**From:** Contact Centre (CRM) <contact@ribblevalley.gov.uk>  
**Sent:** 18 June 2023 11:31  
**To:** Planning  
**Subject:** Planning Application Comments - 3/2023/0216 FS-Case-524786740

**Planning Application Reference No.:** 3/2023/0216

**Address of Development:** Cross Lane Bashall Eaves BB7 3NA

drawing number BE-25-10-22-C

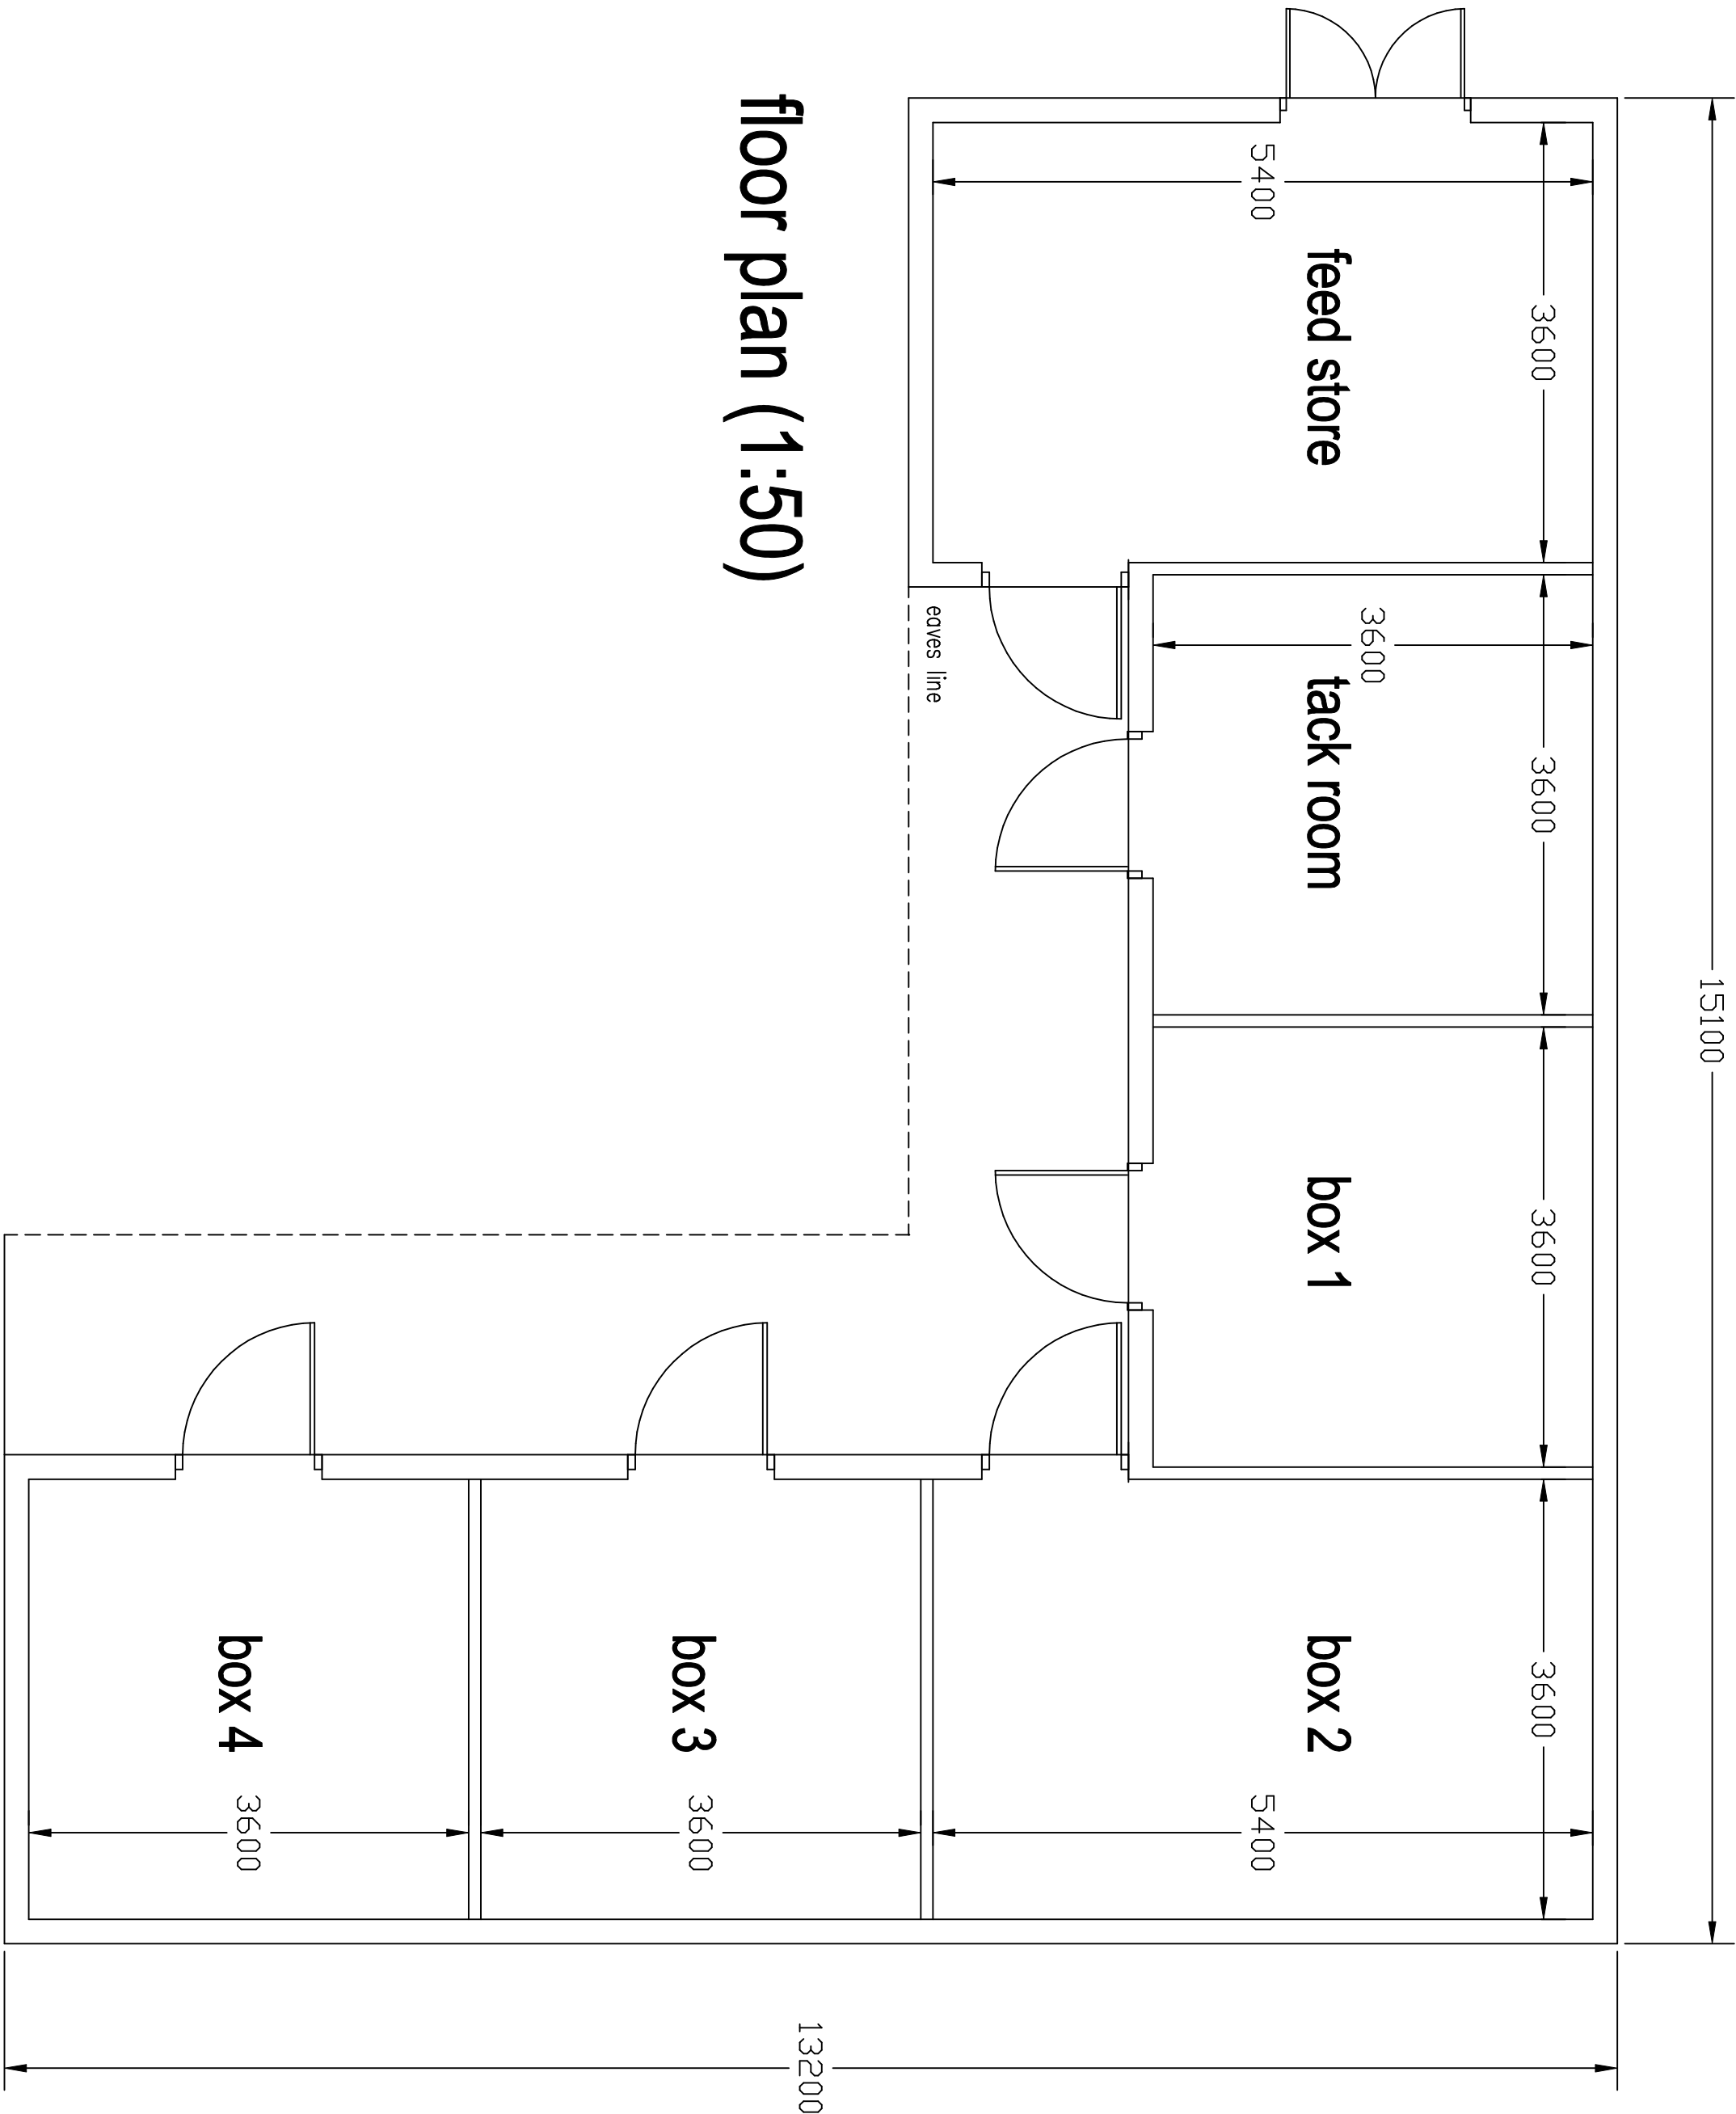
2) Our [REDACTED] (including [REDACTED]) have a [REDACTED] the proposed site. This aspect is not screened by hedging and as the building now protrudes into the field for over 15m this now impacts even more.

3) A 60m x 20m manège, which the plan would suggest when in relation to the size of the building (or is it 60ft x 20ft as shown on the plan) is much larger than others in the area, therefore it would be incongruous in the landscape. It is not necessary to have such a large arena to exercise or train horses that are ridden for recreation. We also question the construction plan of railway sleepers when the ground falls away from the building by 1.34m

5) An uncovered muck store will bring a negative visual impact as well as introduce unpleasant smells and allow rainwater to degrade the muck and turn it into effluent which can then overflow and run into the dyke just below which will run into Bashall Brook causing pollution.
